Appeal Decision

Appeal Ref: APP/R5510/D/22/3296974

12 South Drive, Ruislip, HA4 8EX

- The appeal is made under section 78 of the Town and Country Planning Act 1990 against a refusal to grant planning permission.
- The appeal is made by Mr Adam Macintosh against the decision of London Borough of Hillingdon.
- The application Ref 13950/APP/2021/4433, dated 4 December 2021, was refused by notice dated 31 January 2022.
- The development proposed is side extension.

CLIENT  
ADAM MACINTOSH  
PROJECT  
12 SOUTH DRIVE, RUISLIP, HA4 8EX  
DESCRIPTION  
PROPOSED SITE PLAN  
SCALE  
AS STATED  
DATE  
13.11.2021  
DWG NO.  
HA48EX-DWG-014  
REV  
01  
NOTE  
PLANNING

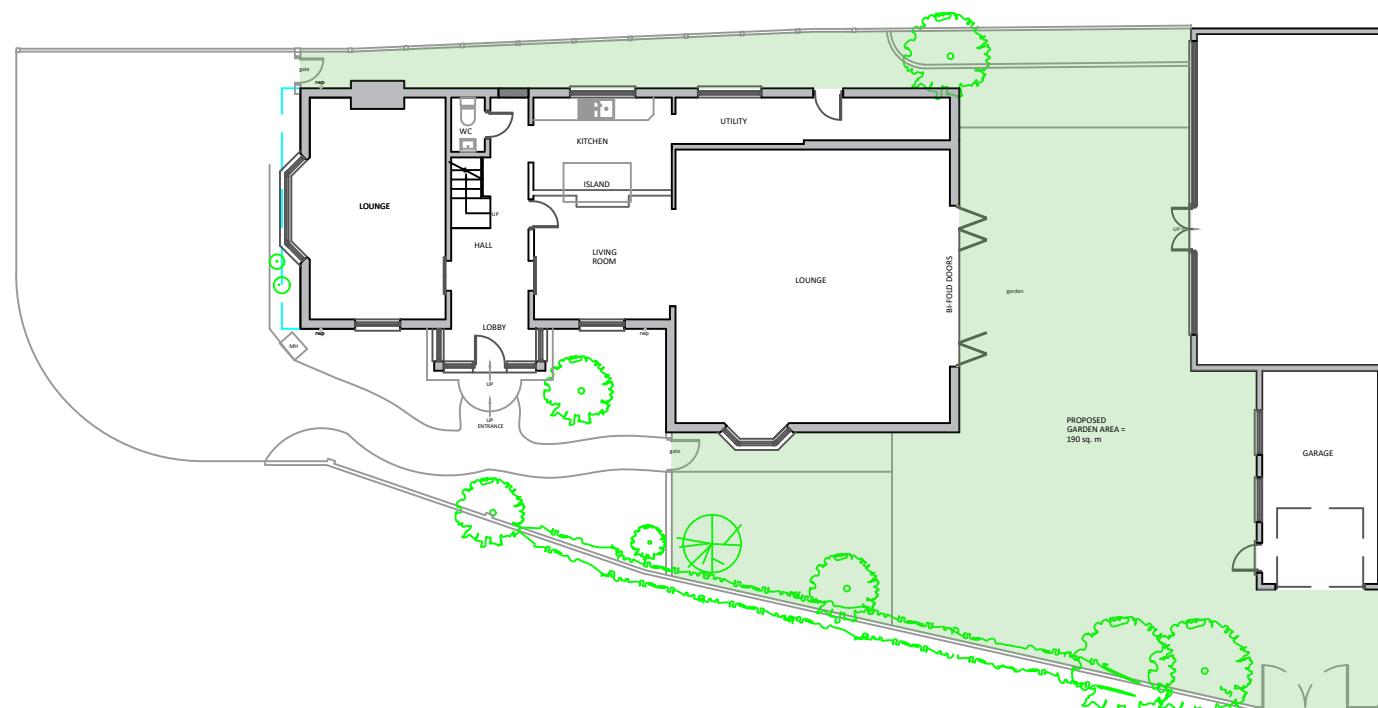
5. The proposed single storey side extension is shown on the submitted plans as being of some scale in itself and in proportion to the existing dwelling, the extension is described by the council as being "approximately max 3 metres in width, 9.2 metres in depth and 3.2 metres in height". Furthermore, the submitted plans show a flat roof over the proposed extension in contrast to the pitched roofs over the appeal property.

6. The submitted plans show, and the appellant has referred to, the screening that would be afforded by the close boarded fence to Croft Gardens, described by the appellant as being some 1.8m high. I note that this screening would be limited to the lower part of the extension only.

7. It is my planning judgement that the combination of the proposed extension, itself of some scale, with the existing two storey extension and enclosed swimming pool would not be subservient in scale, character or appearance to the appeal property and as a result of the prominent location of the appeal property, I find that the appeal scheme would harm the character and appearance of the local area including the Midcroft, Ruislip Area of Special Local Character.
